LOI_V1.pdf Markup Summary

# PLOT PLAN

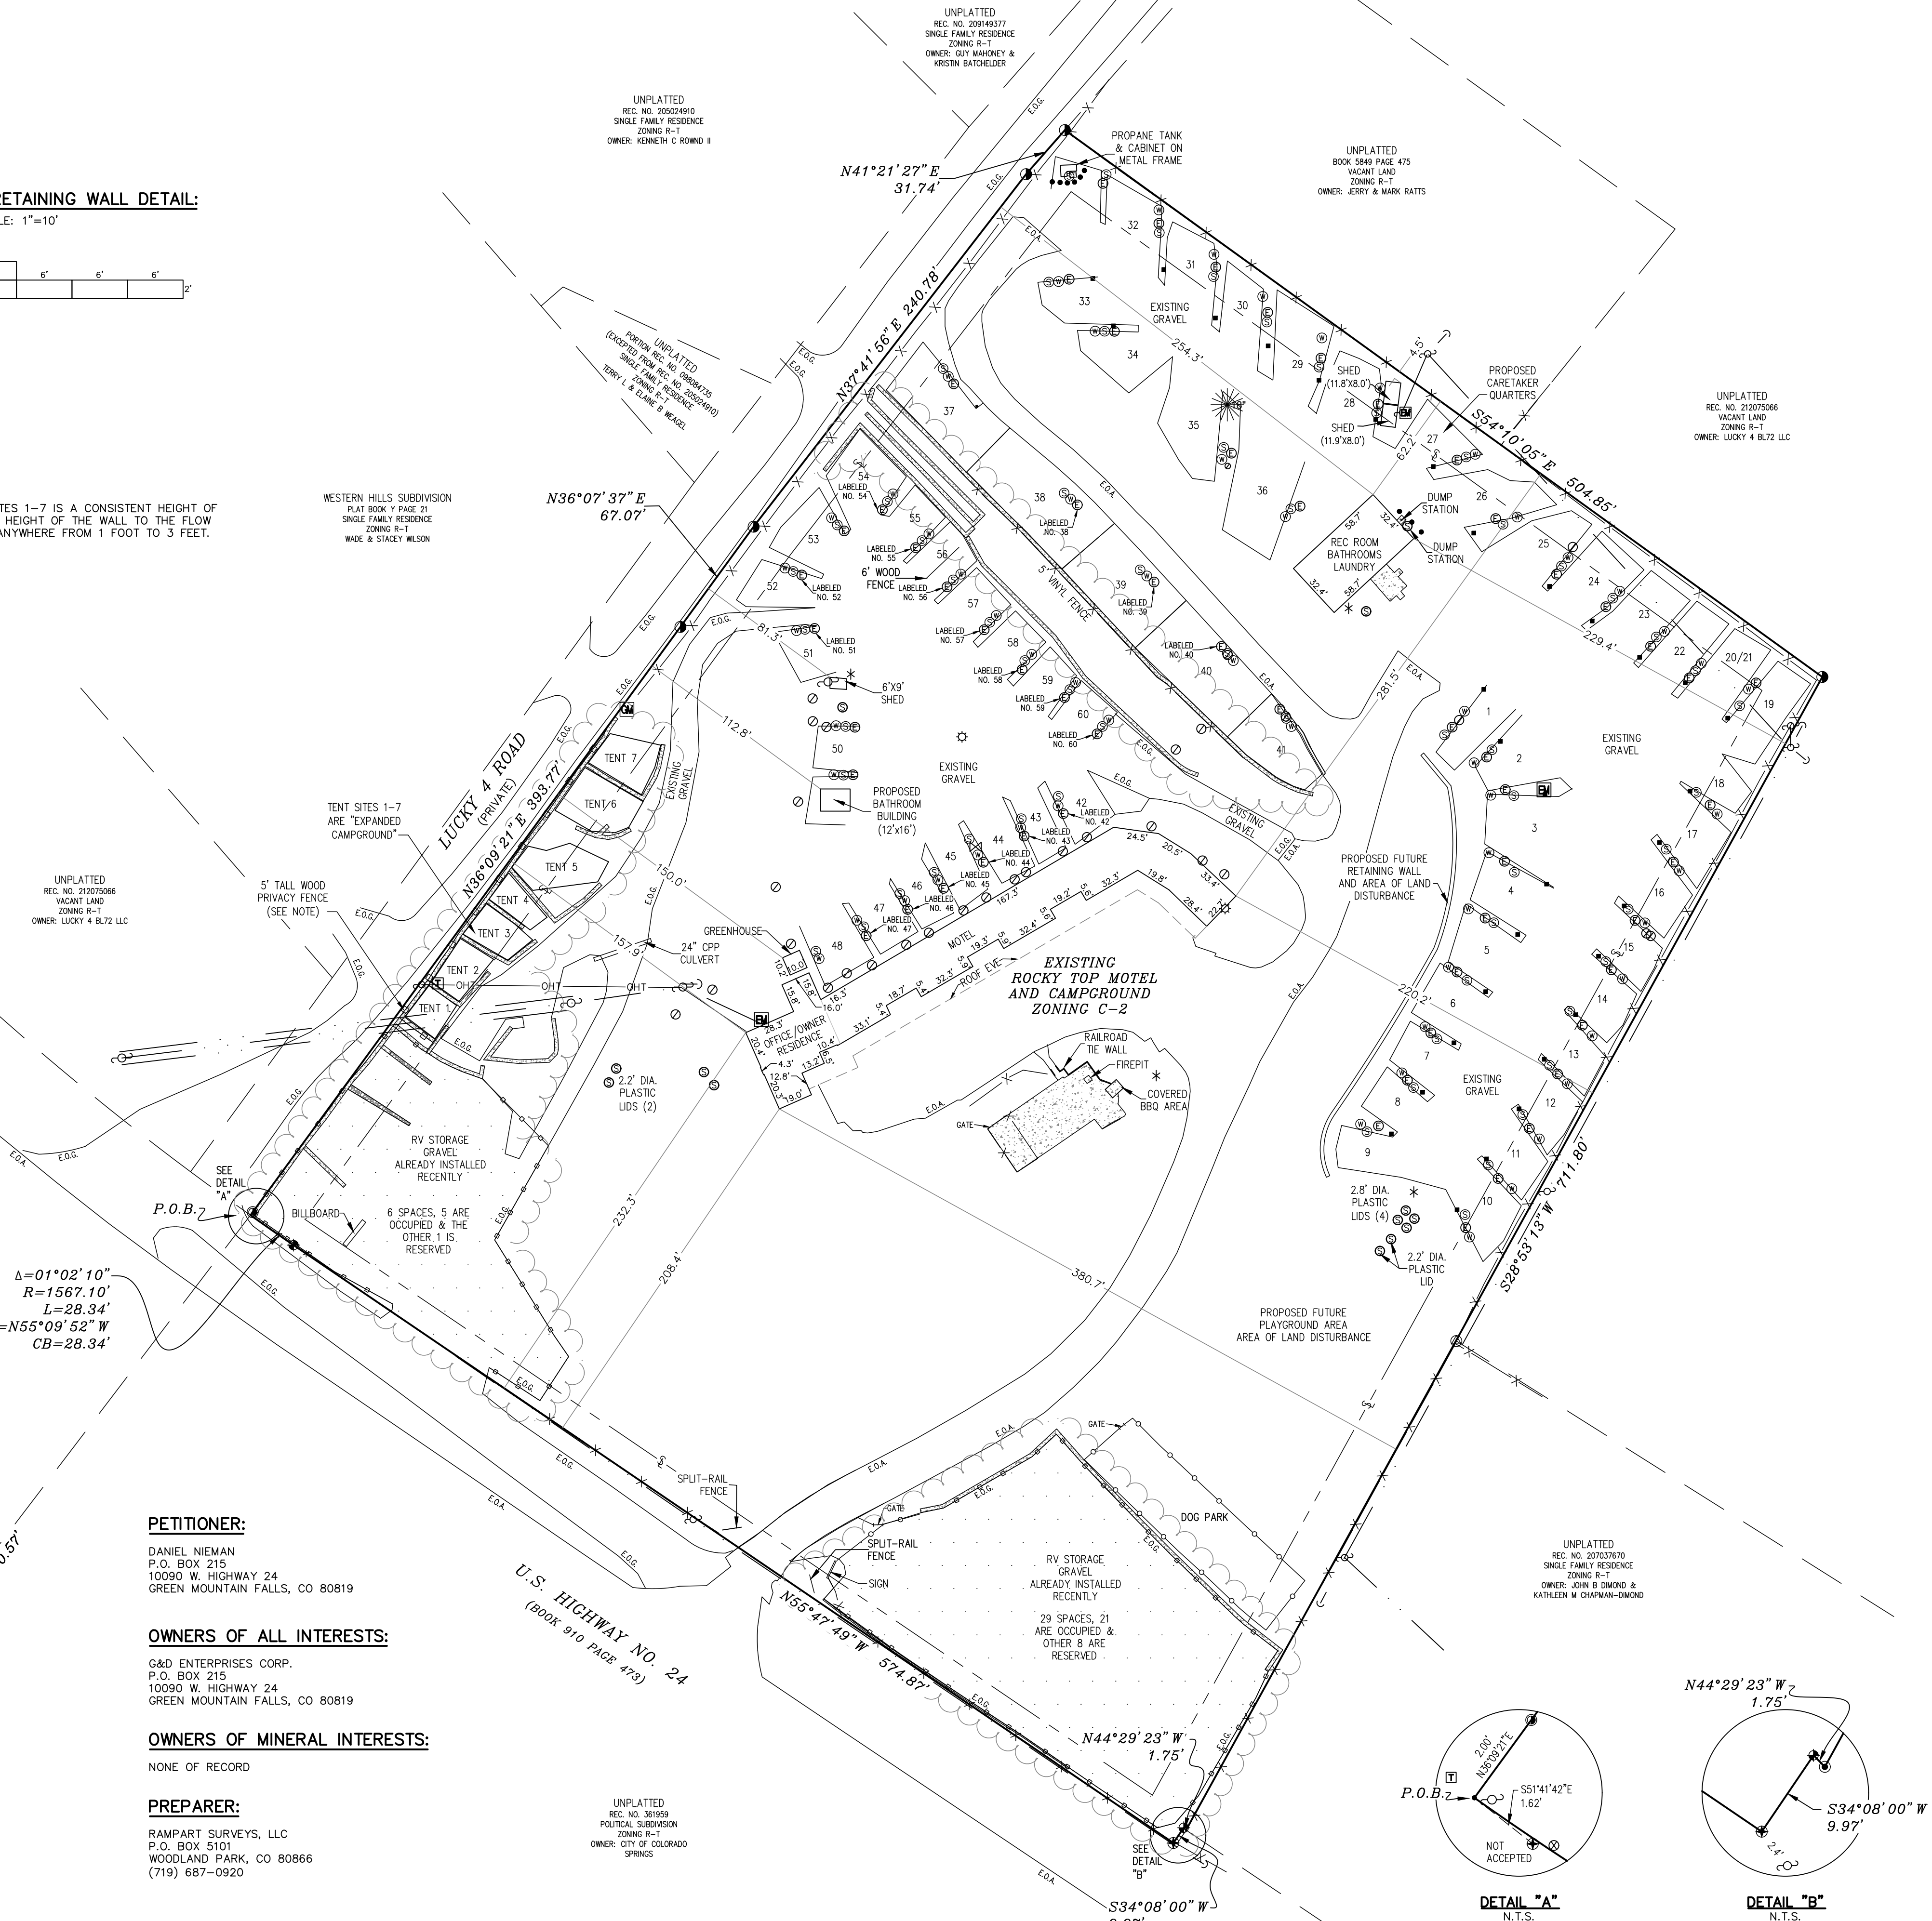
were permits pulled for these retaining walls?

include the distance and how the use is compatible with the adjacent neighbors and how the applicant plans to mitigate site issues with screening, etc
